**Consultation Response from KC,
Lead Local Flood Authority**

2025/93500 adj, 208, Yew Tree Road, Birchencliffe, Huddersfield, HD2 2EQ

Discharge of details reserved by conditions 6 (Phase II Intrusive Site Investigation Report), 7 (Remediation Strategy), 14 (Temporary drainage), 16 (drainage strategy, 17 (drainage attenuation), 23 (construction traffic), 26 (EVC) on previous permission 2018/90151 for outline application for erection of residential development

Date Responded: 16th January 2026

| Rev | Details | Date | Drawn | Chk. |
|--------------------------------------|---------|------|-------|------|
| Surface Water Management plan | | | | |

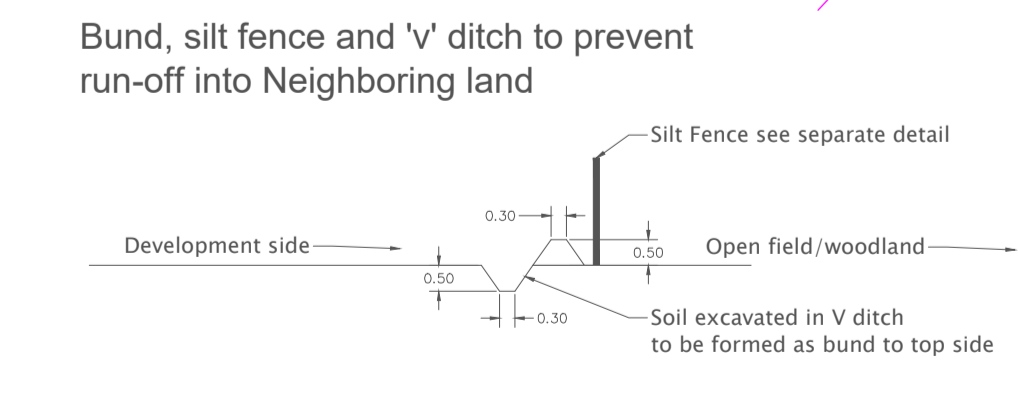
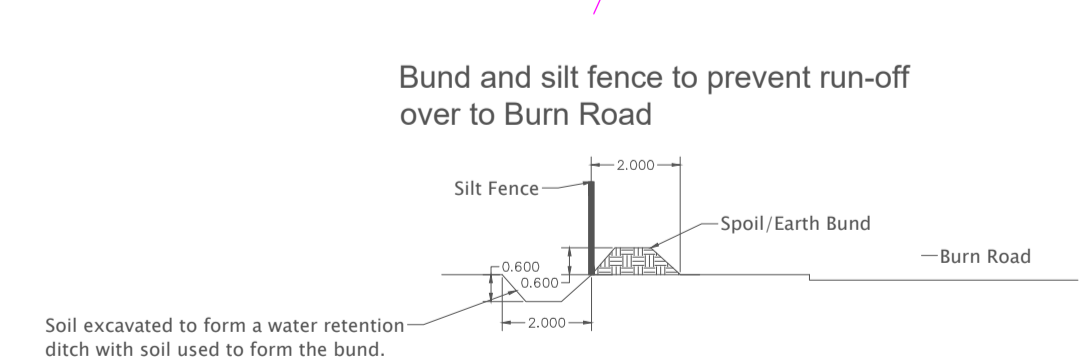
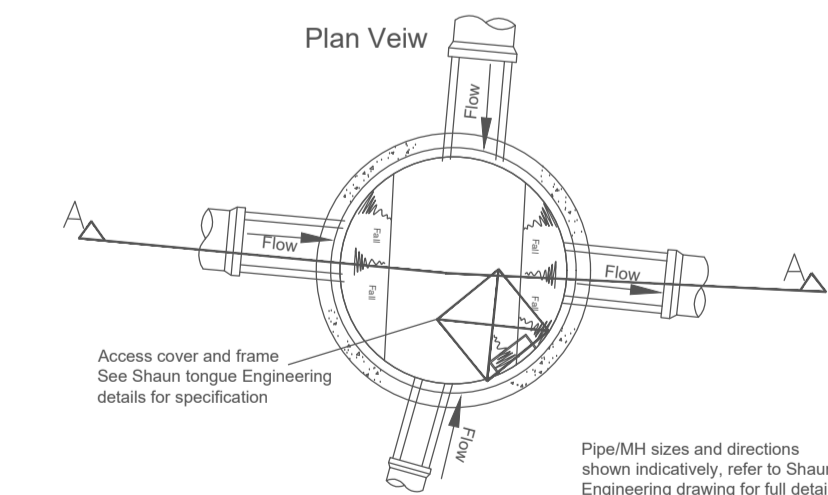
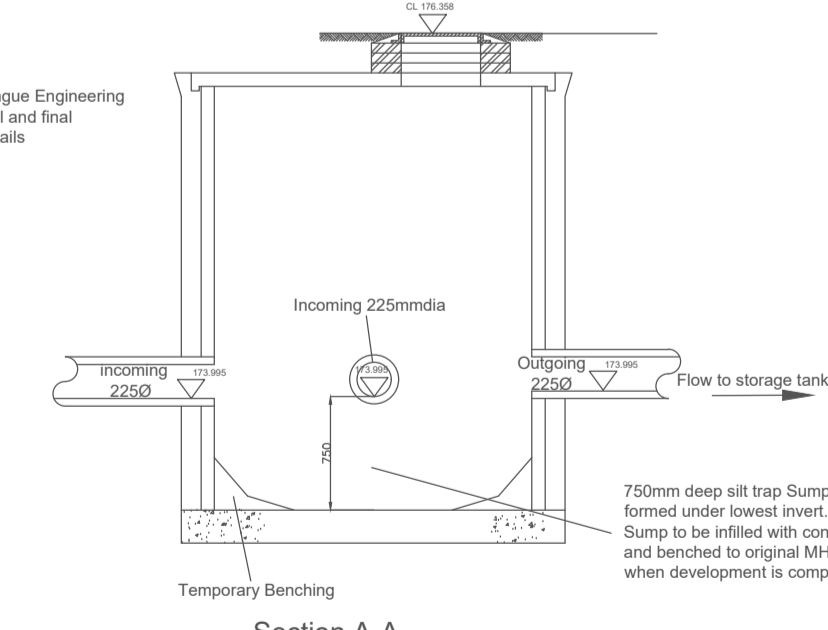
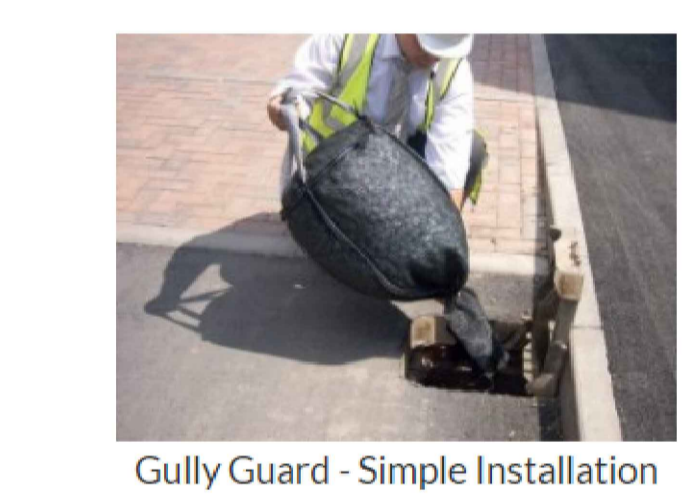
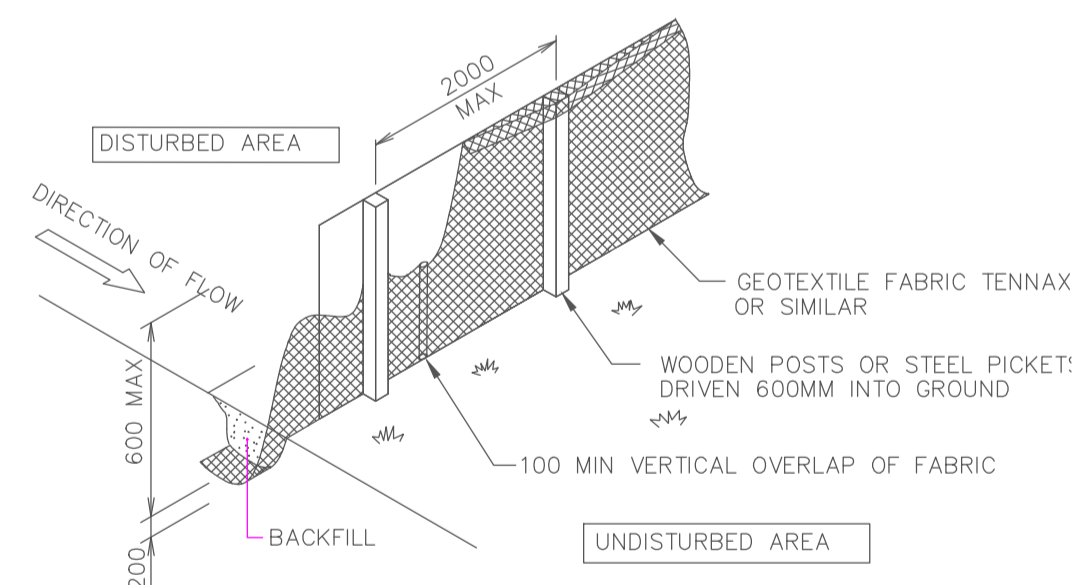
A plan has been submitted for temporary drainage. A narrative should accompany this looking at how risk has been identified and a list of the mitigation measures and how they are managed. A site should look to contain run off in the stage between site clearance and the attenuations tank being installed. For a site this size the 1 in 1 year 6-hour event should be considered.

We do NOT recommend that this condition be discharged at this moment in time.

**DRAWING TITLE:** NEWETT HOMES  
YEW TREE ROAD, BIRCHENCLIFFE  
2.0m DEEP ATTENUATION TANK  
BASE LAYOUT

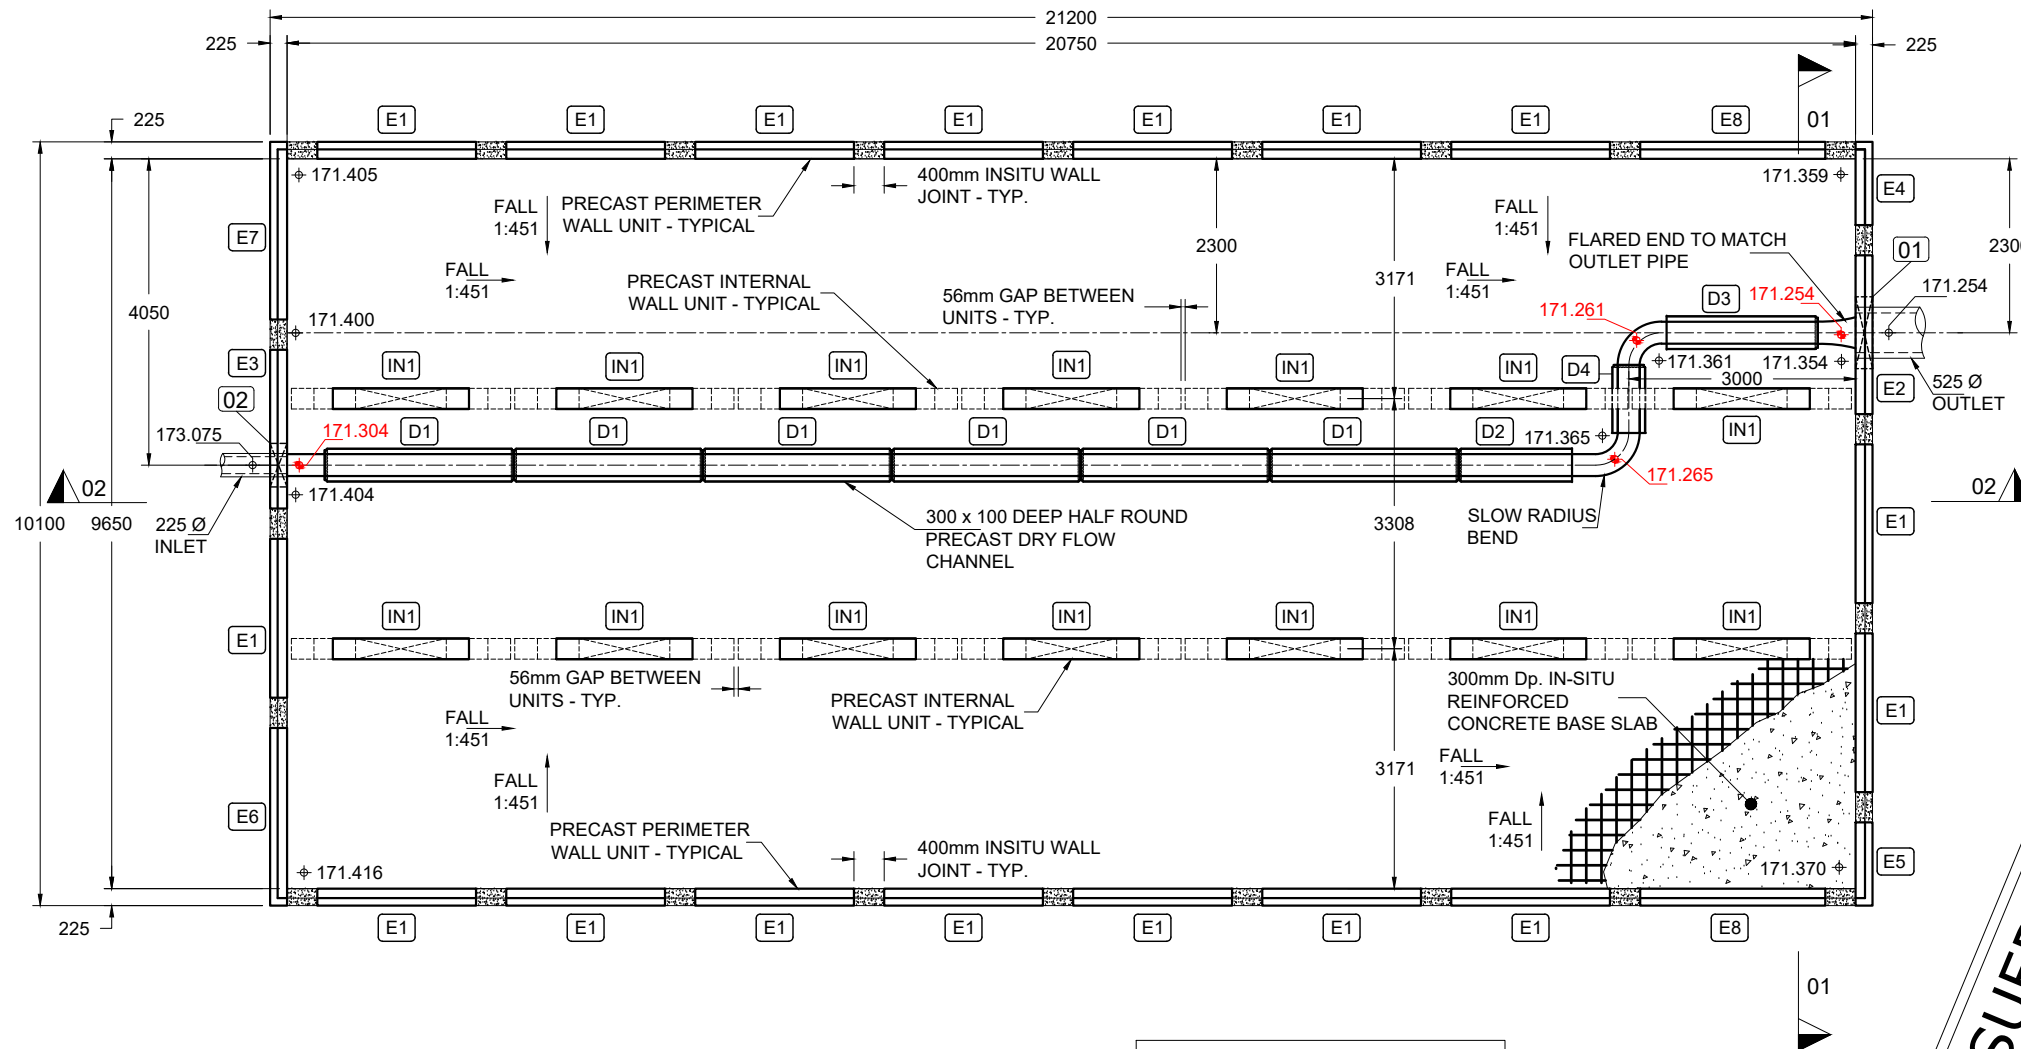
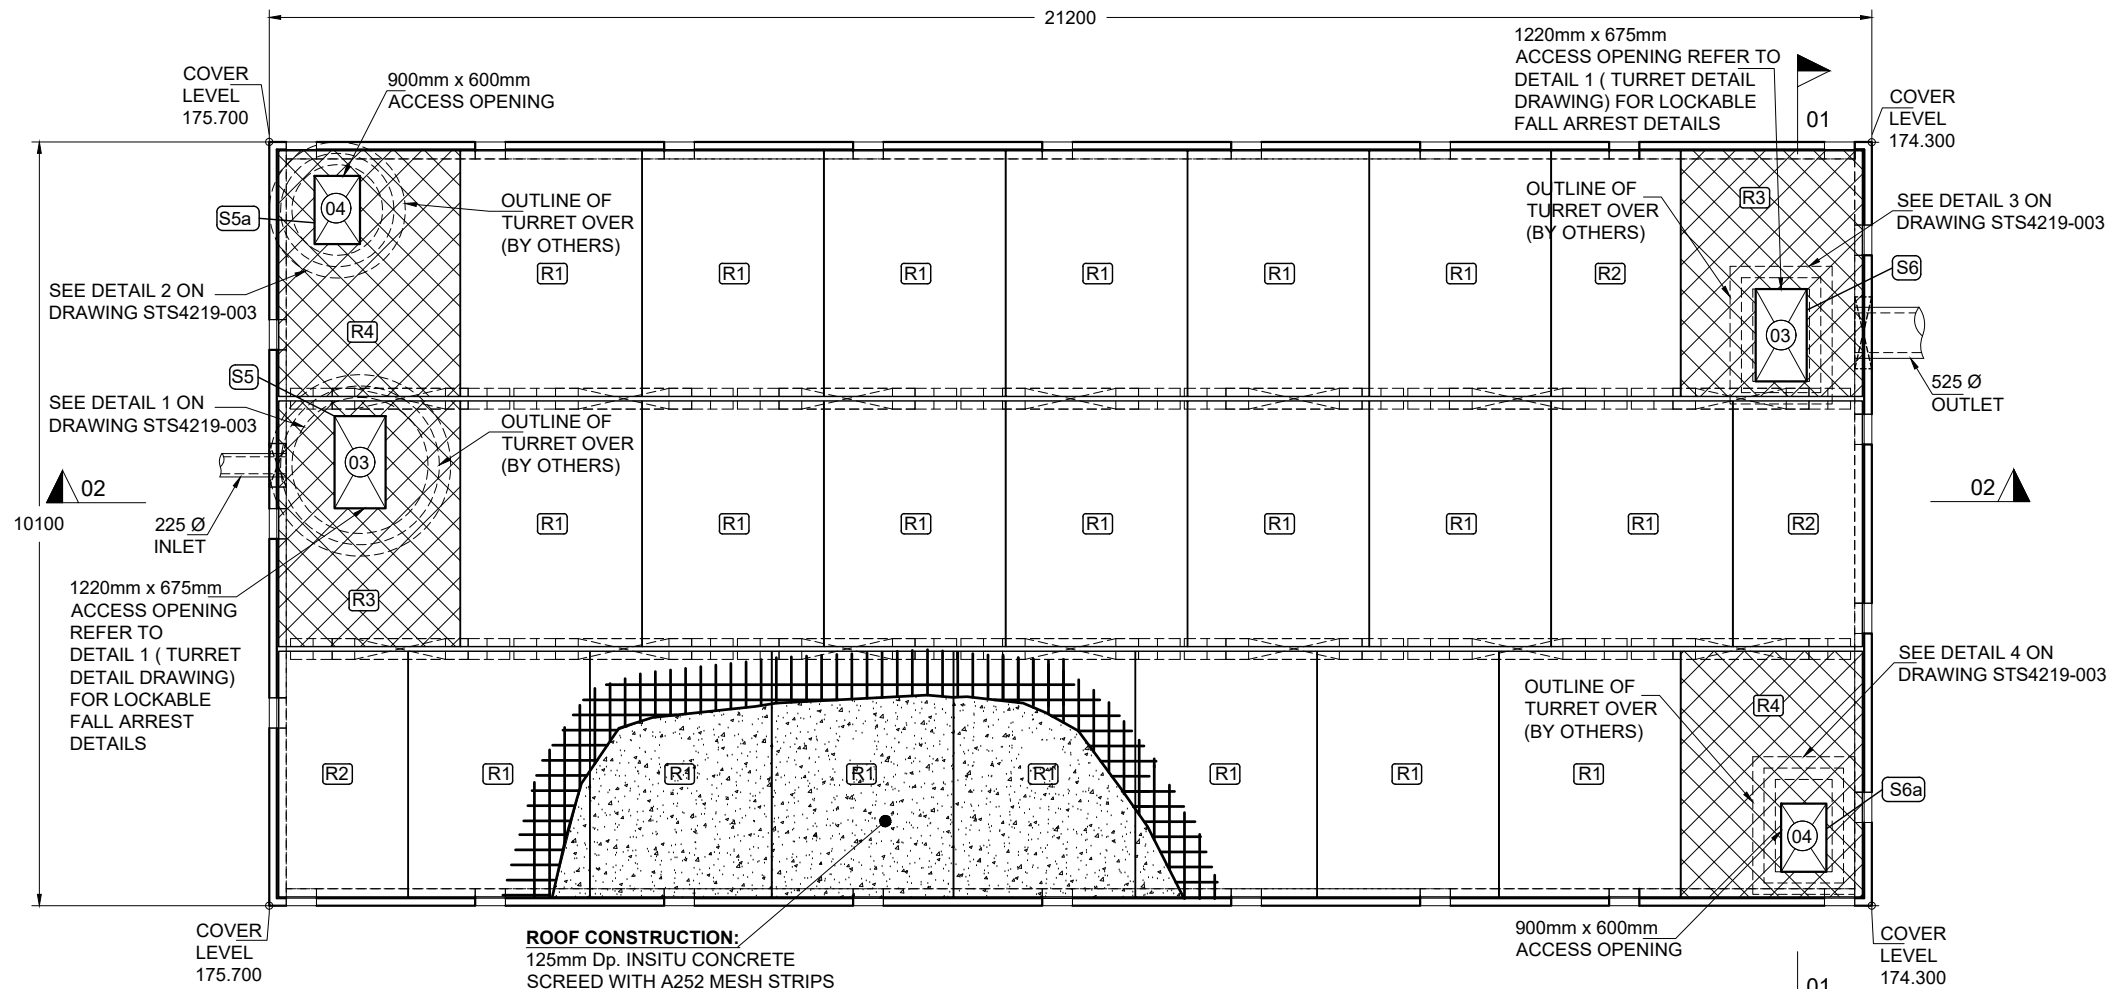
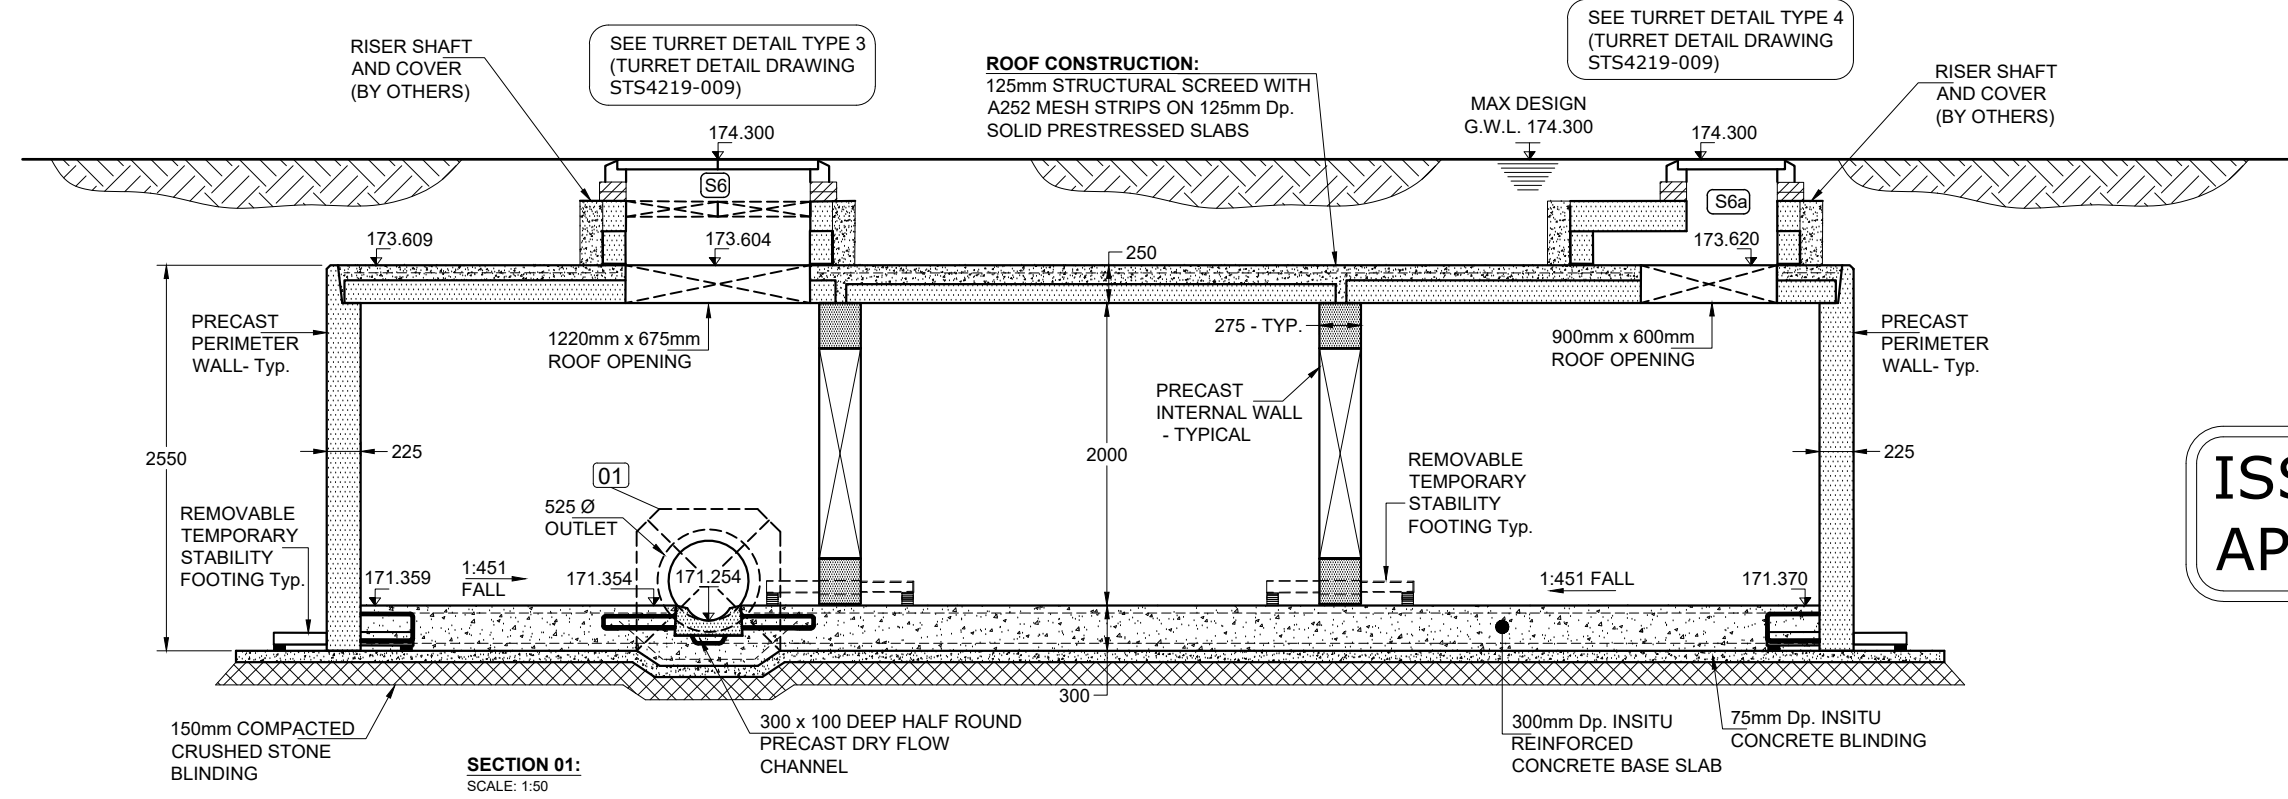
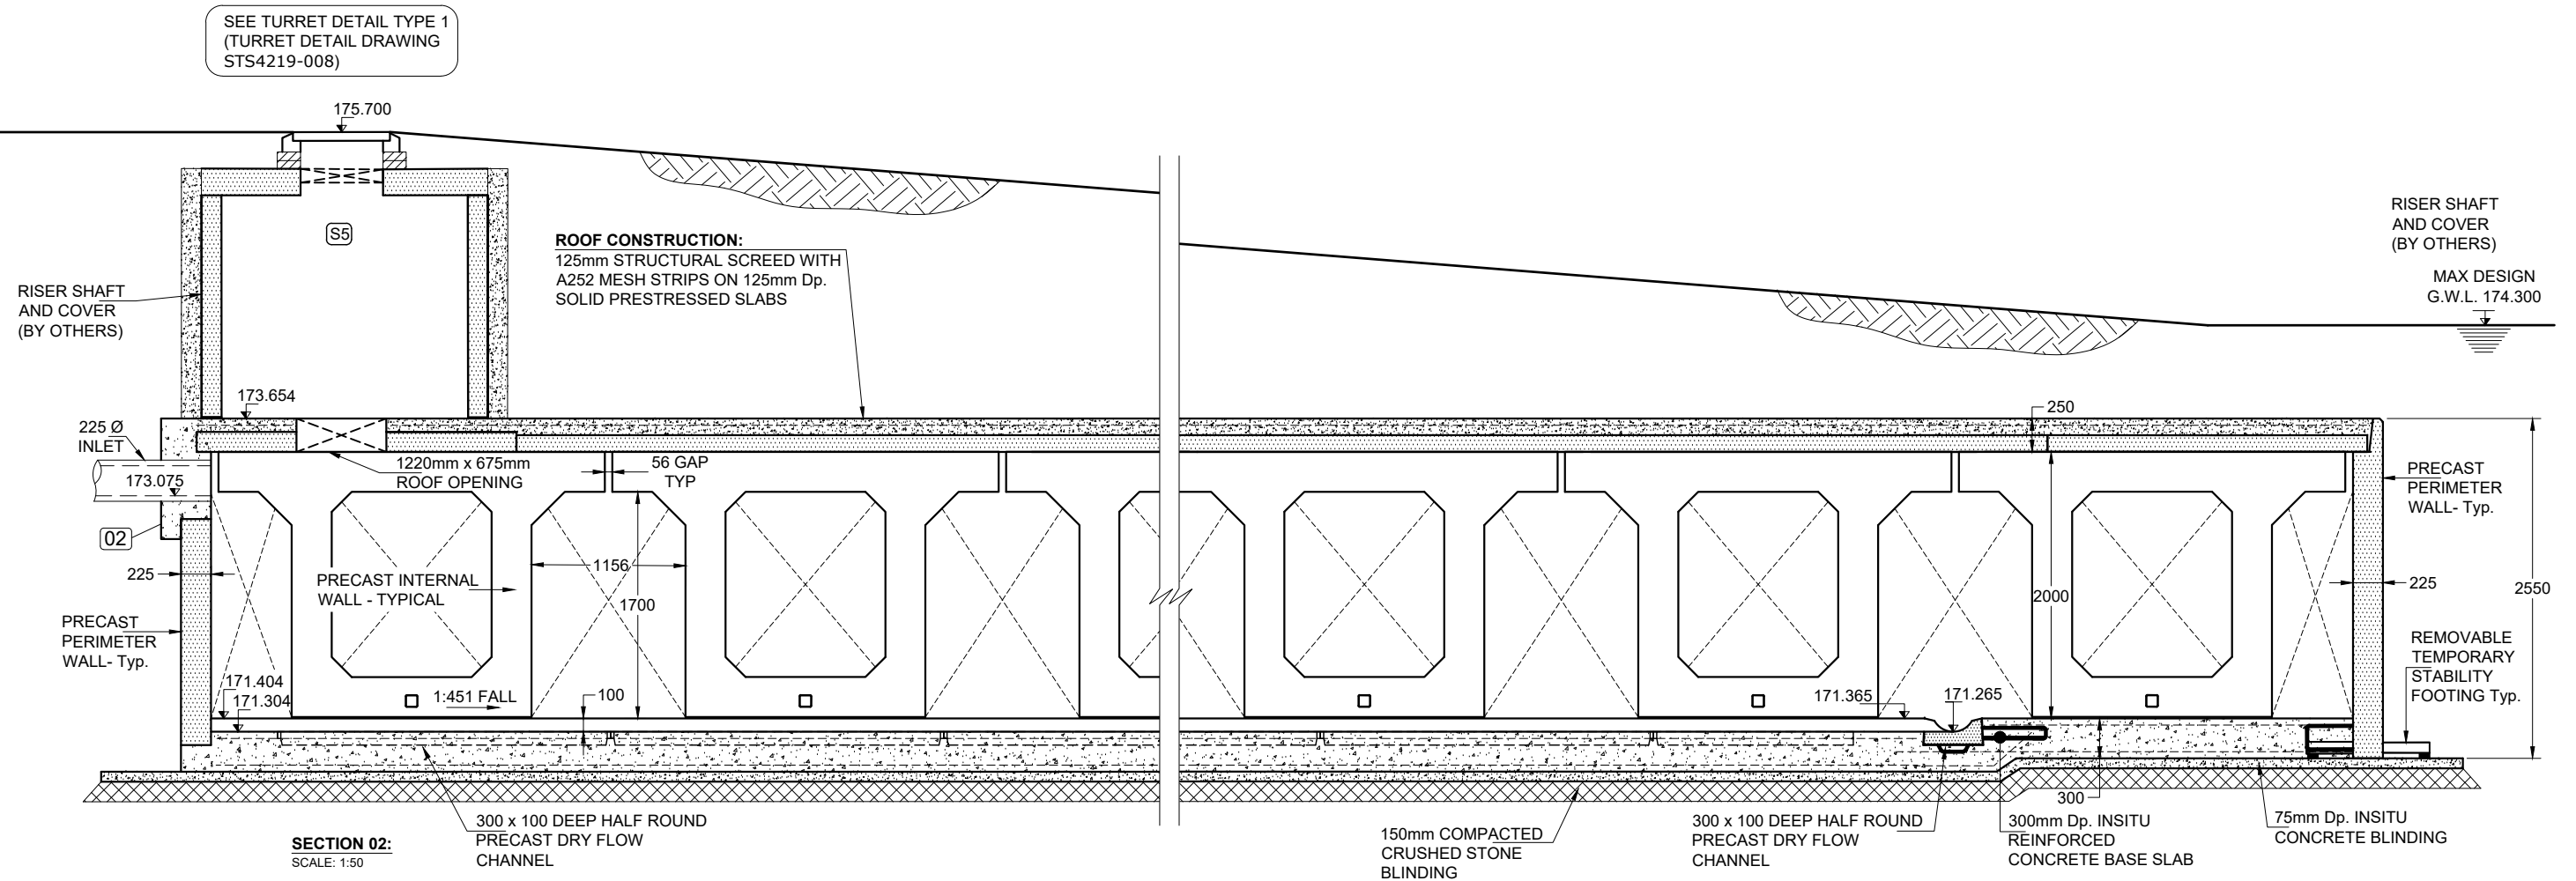
Full details of the tank, plan and cross section are required.
